Your Ref: OWQC16552
Our Ref: EP/145/17/HH
Please ask for:
Mr M Jones

Extend garage & form pitched roof over. Single storey infill extension between enlarged garage & house. Formation of enlargement to existing dormer on SE elevation & addition of pitched roof to existing dormer on NW elevation. Removal of tile hanging from gables & dormers & fitting fibre cement weather board.

9 Nursery Close East Preston

DRAWING TITLE
Proposed Elevations 2 of 2

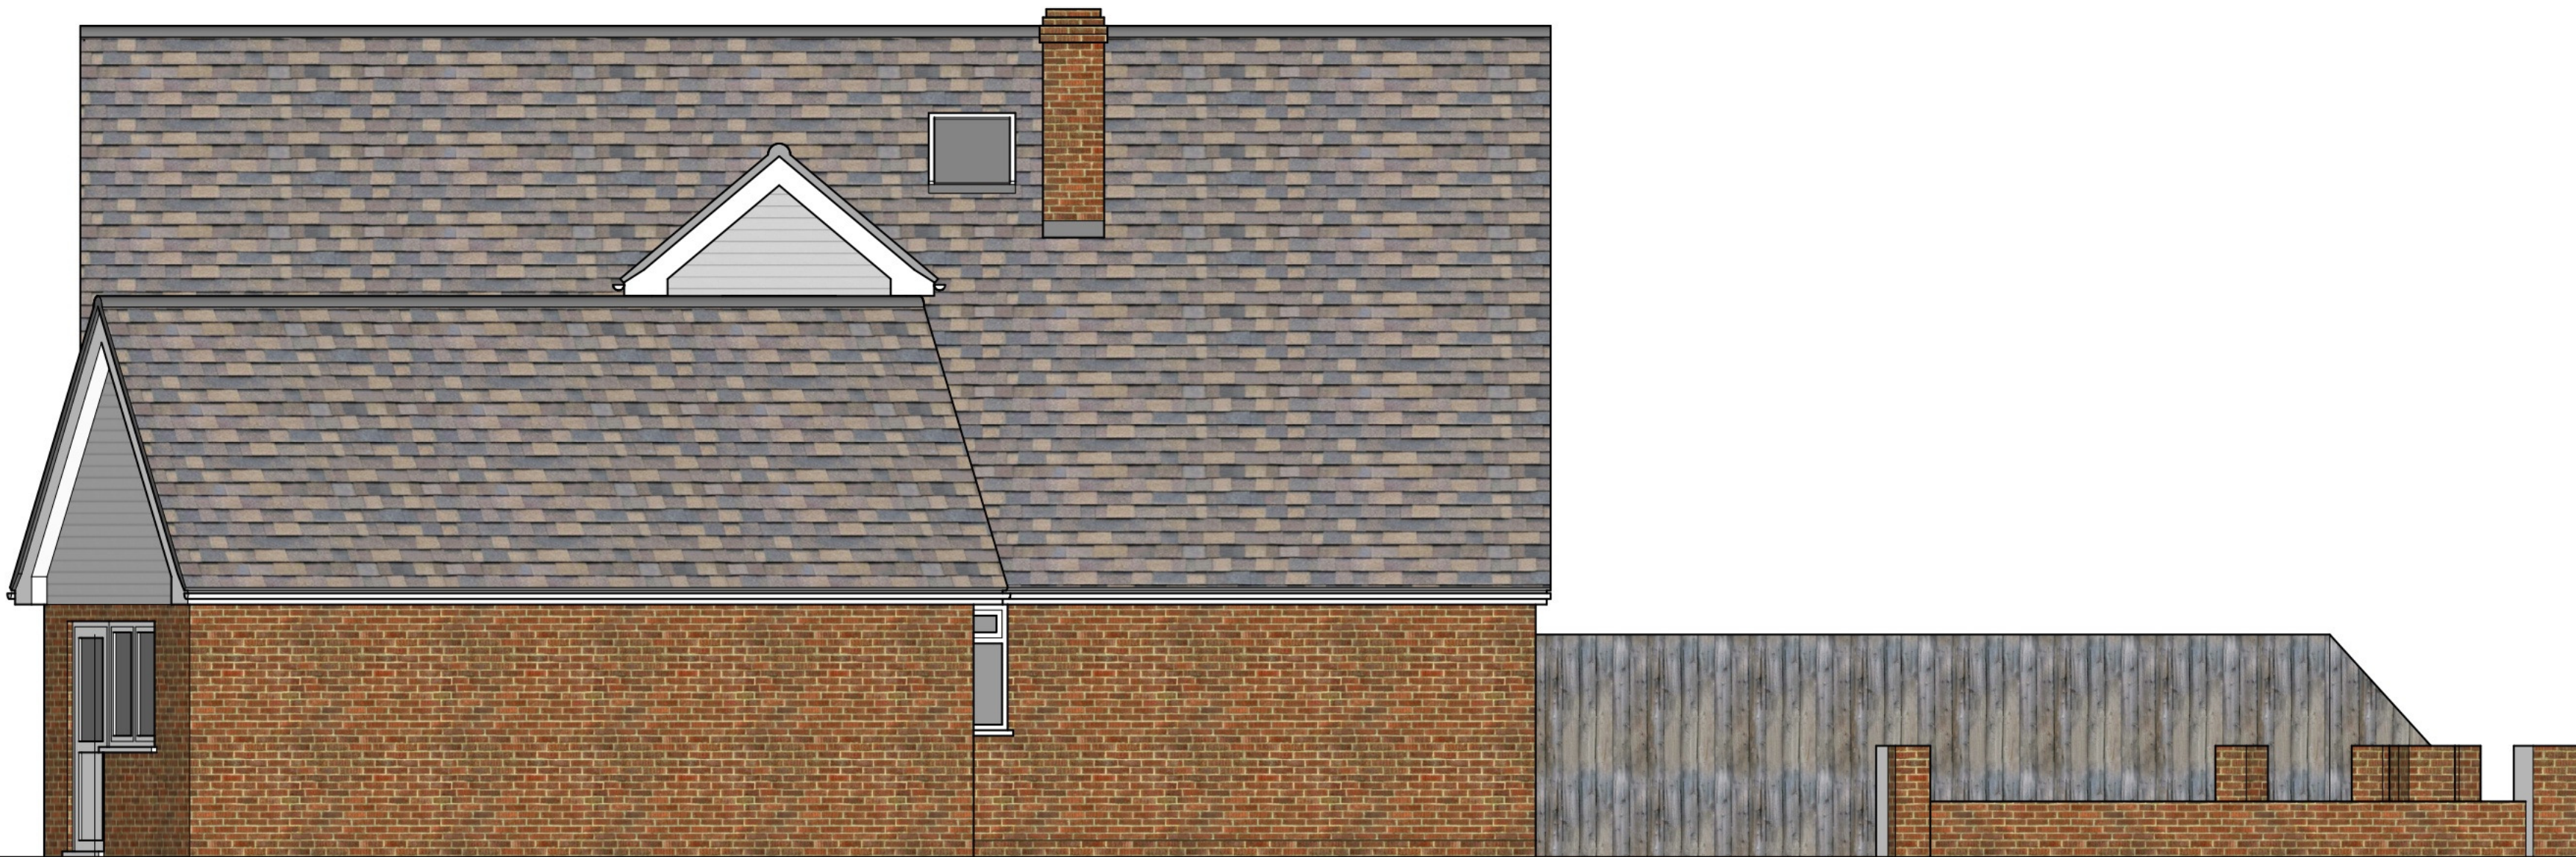
The proposed dormer may well result in an unbalanced property and is out of proportion to the existing property. The proposed pitch of the garage roof seems unnecessarily steep and will look out of place. The proposed materials, in particular cladding, will be out-of-keeping and contrary to the made East Preston Neighbourhood Plan. For these reasons, this council asks Arun District Council to consider refusing Planning Permission for this proposal.
